From: Jay Sharma <Jayanta.Sharma@customerservice.nsw.gov.au>
Sent: Wednesday, 22 April 2026 11:54 AM
To: Mario D'Addona
Cc: Julia Green; Jessica Watson; Amy Alessi
Subject: RE: Telco Authority - Agency Advice - Wallaby Creek Wind Farm (SSD-60247211)

At this stage, based on the turbine locations provided, we acknowledge turbines 68 and 71 are close to two microwave links between Sappa Bulga and Peak Hill (ACMA Licences 1806335/2 and 1806336/2). However, we do have plans to decommission both licenced links by mid-2027.

Figure 6: Link 4 passing through the project area

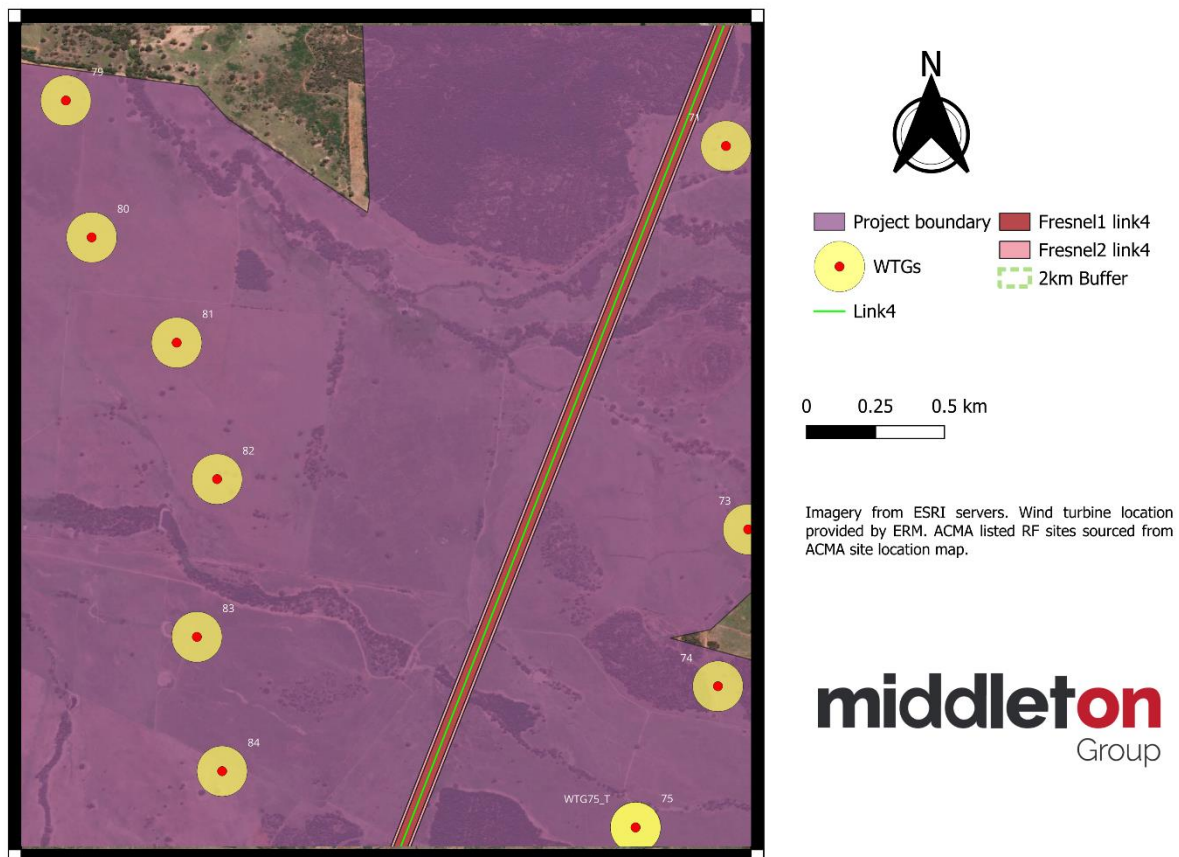
We'd like to get updates on construction schedules for the farm and to track it with our decommissioning of the links. Is Tess McGahan (tess.mcgahan@acciona.com) still the best contact person for project updates?
